Submission Regarding Building C Block – Timber Demountable Ballina Coast High School

The building known as C Block is the Ballina High School historic timber building located on the north side of the aquaculture shed, adjacent to the main oval. Over the years, it has been used for many purposes.

**1 A-002 SITE PLAN**  
1 : 400

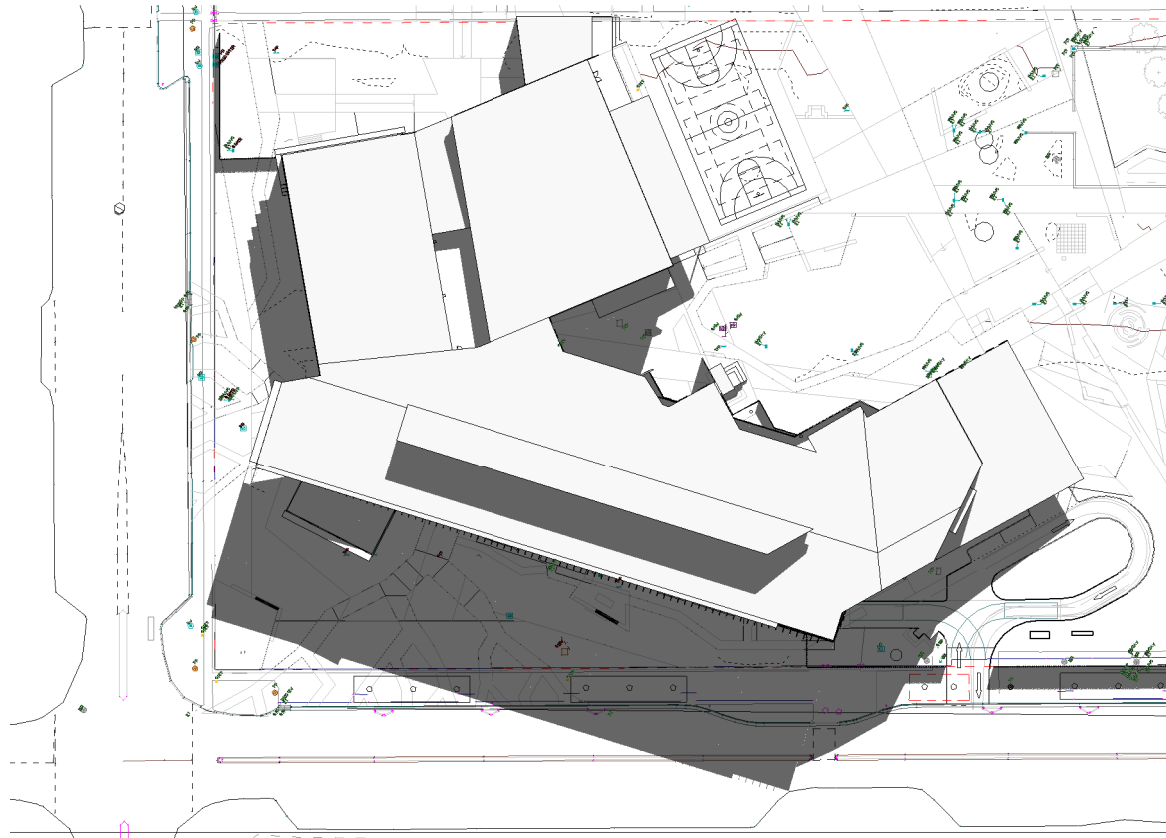
In the Project Overview on Page 9 Appendix C Development Plan Part B, the building is labelled "Future Agriculture," "Garden Store," and "Outdoor Equipment Store." I believe that a timber building is not suitable to store petrol operated garden and outdoor equipment, oils and chemicals for agriculture and garden use. Currently, there is a double colourbond shed between the Marine Discovery Centre and the Hospitality complex, accessible from Martin Street and from the school playground. This shed has always been used to house the tractor (prior to the zero turn being purchased), ride on mower/s, push mowers, garden equipment, tools etc.

On behalf of the *Ballina Schools' Historical Society Inc.*, I request that the classroom space C1 be made available to the society for the purpose of displaying and storing the Ballina High School and other Ballina Shire school memorabilia. The remaining two rooms of the building could be used for "Future Agriculture" and storage.
